WEST SUSSEX COUNTY COUNCIL CONSULTATION

TO:	Arun District Council FAO: Anita Gardner
FROM:	WSCC - Highways Authority
DATE:	7 March 2019
LOCATION:	Rear of Caffyns Audi Worthing Roundstone By-Pass Littlehampton BN16 4BD
SUBJECT:	A/175/18/PL Temporary car park extension
DATE OF SITE VISIT:	
RECOMMENDATION:	More Information
S106 CONTRIBUTION TOTAL:	£ See below for breakdown.

Figure 4: Proposed site layout for temporary car park extension

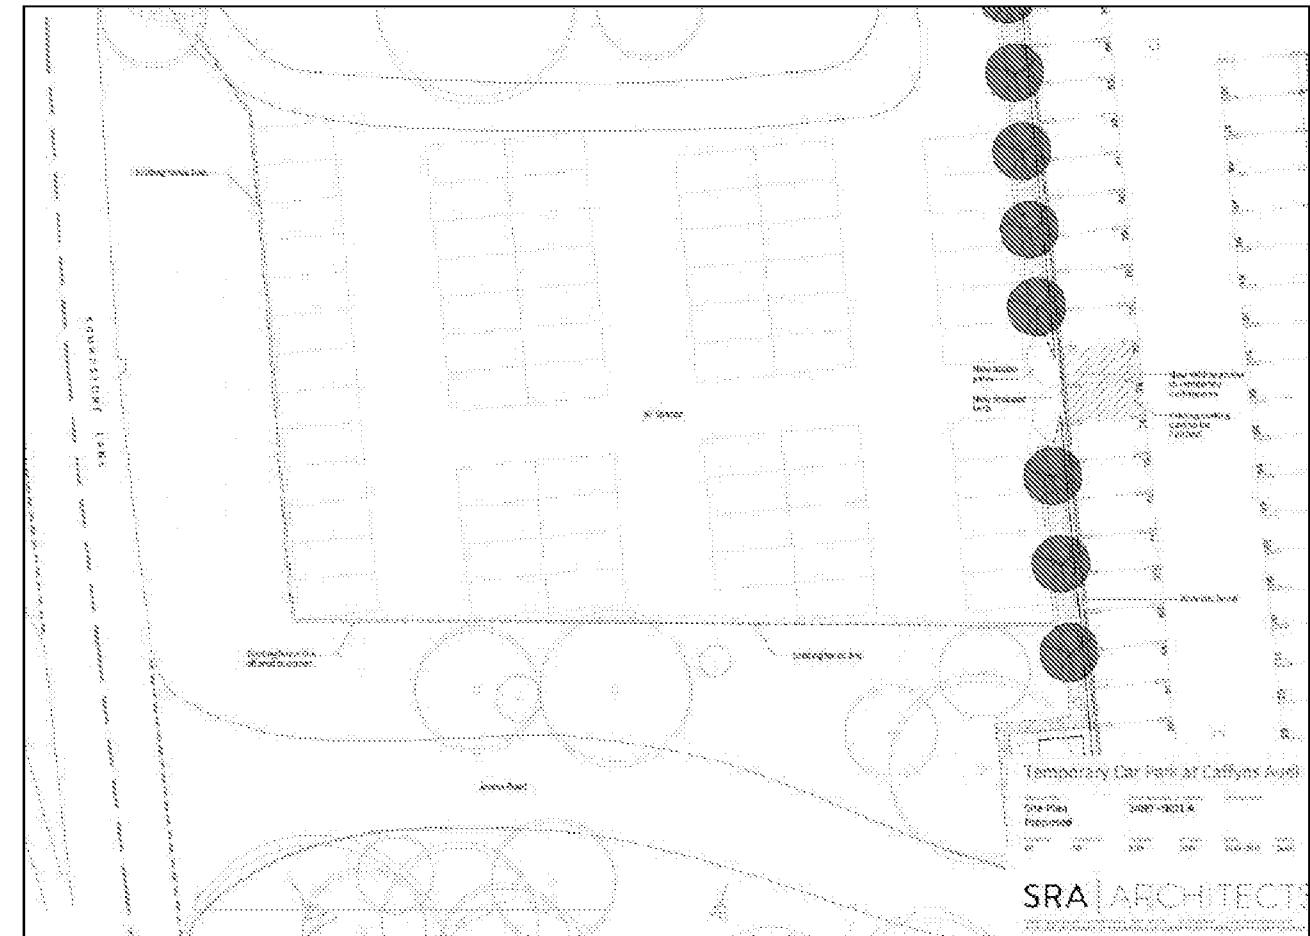
The information provided with the application is limited. The proposed site plan (3480-060) shows the proposed parking area only and the location plan appears to show the main left in/left out (LILO) access with a barrier. A plan showing a fence and gate has been submitted however it is not clear of the location - can the applicant confirm it is between the existing and the proposed/new parking area.
